Our Ref: TR040011

Application by North Somerset District Council for an Order Granting Development Consent for the Portishead Branch Line – MetroWest Phase 1

Advice following issue of decision to accept the application for Examination

- Order Limits
Centreline of Work
Limits of Deviation
Extents of Work

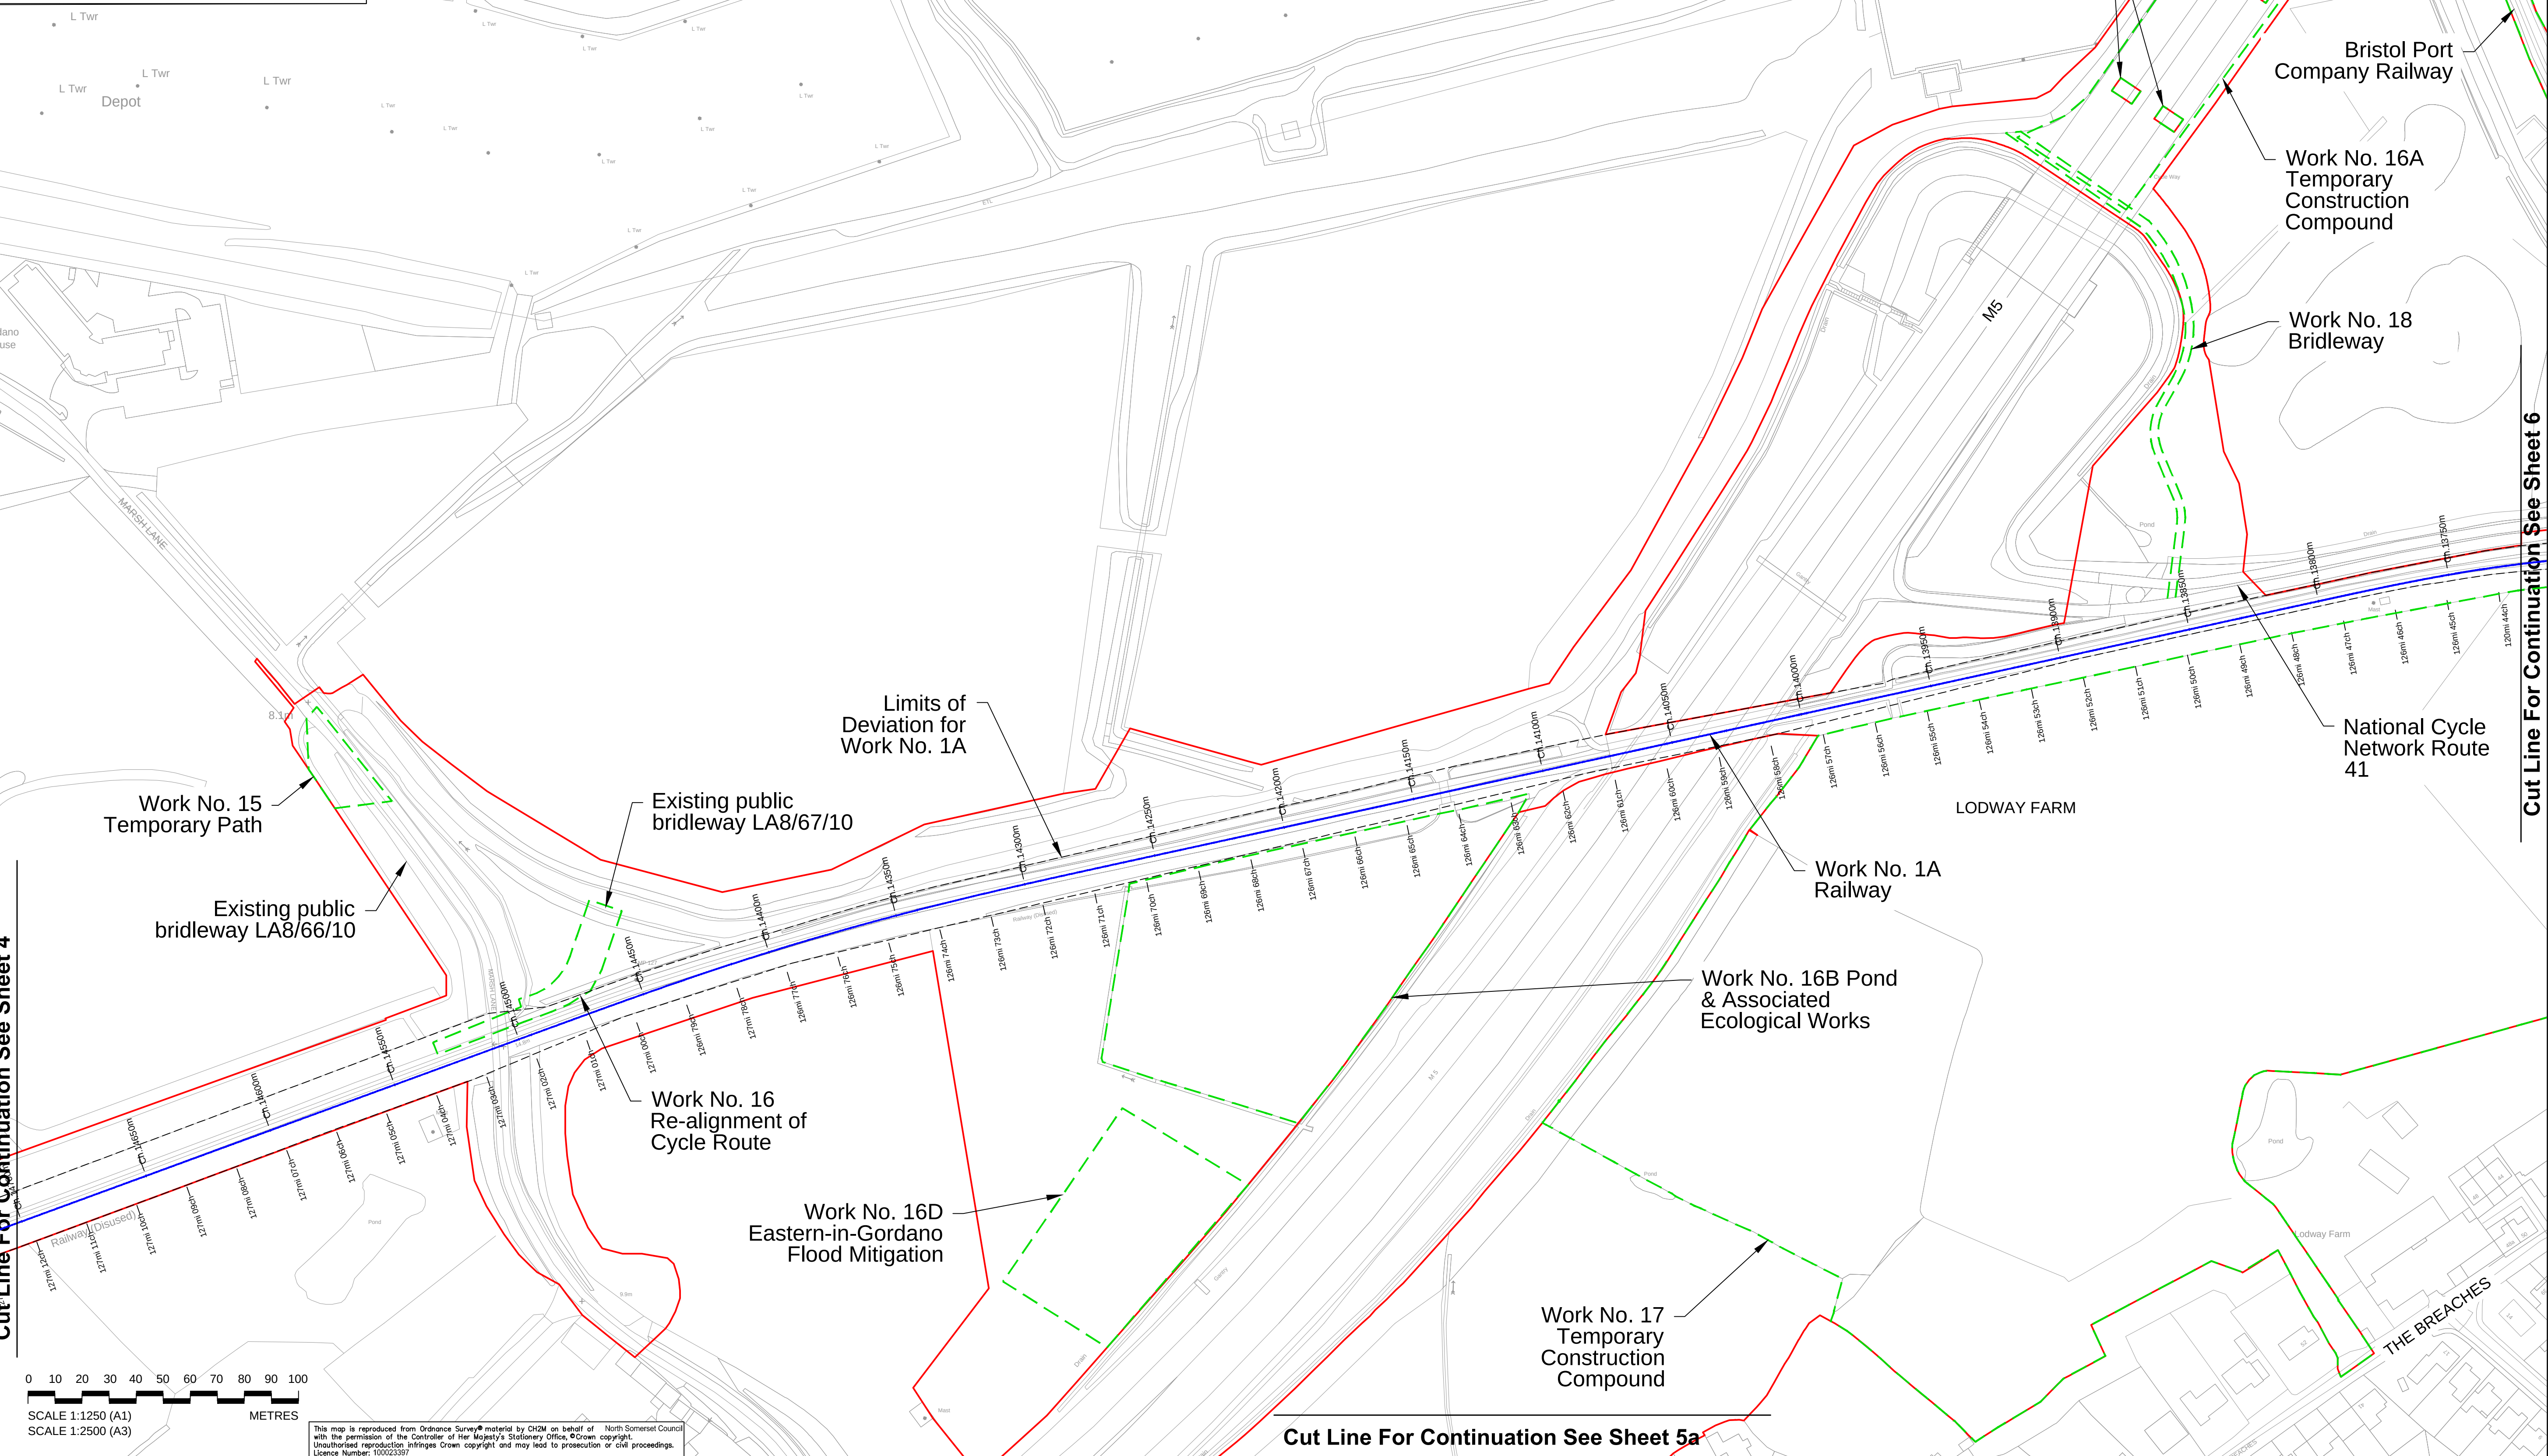
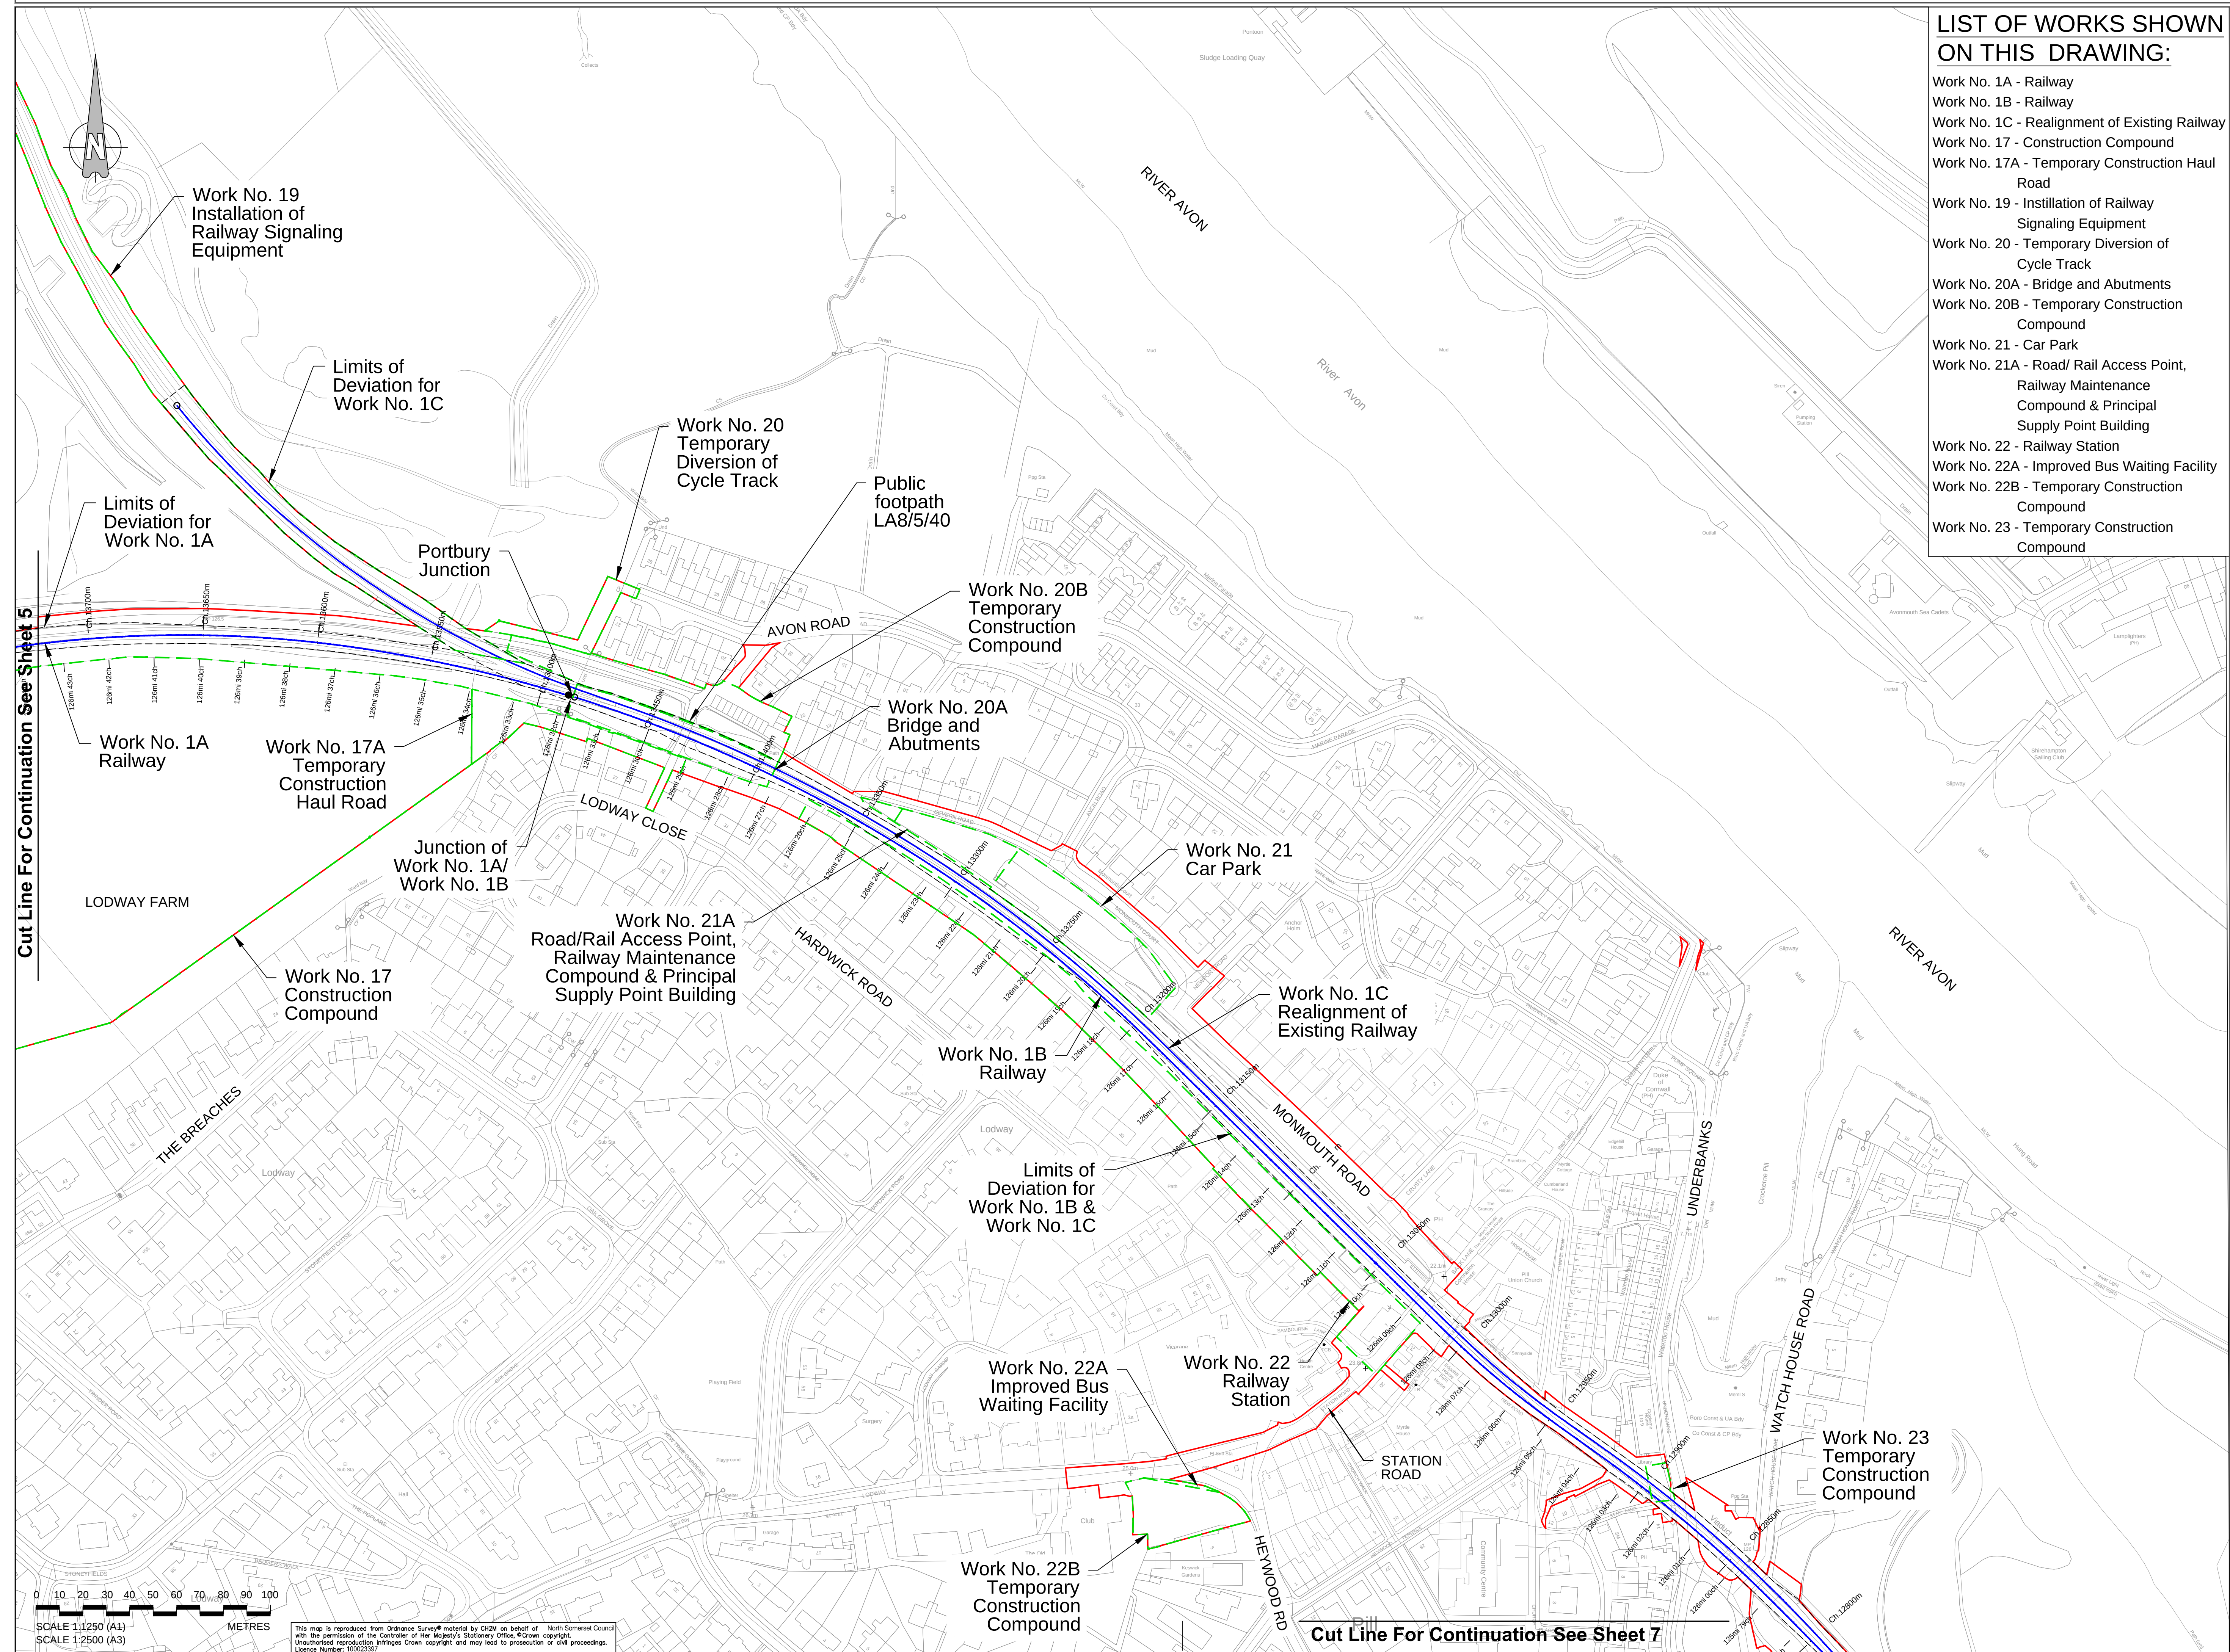
There are also inconsistencies between the Description of the Works in Schedule 1 of the draft Development Consent Order and the Works Plans (**Doc 2.3**) (eg Works Plan 2a, 7e, 13a).

The Applicant is advised to carry out a comprehensive check of these documents to ensure all information provided is complete and accurate and provide updated documents, if required.
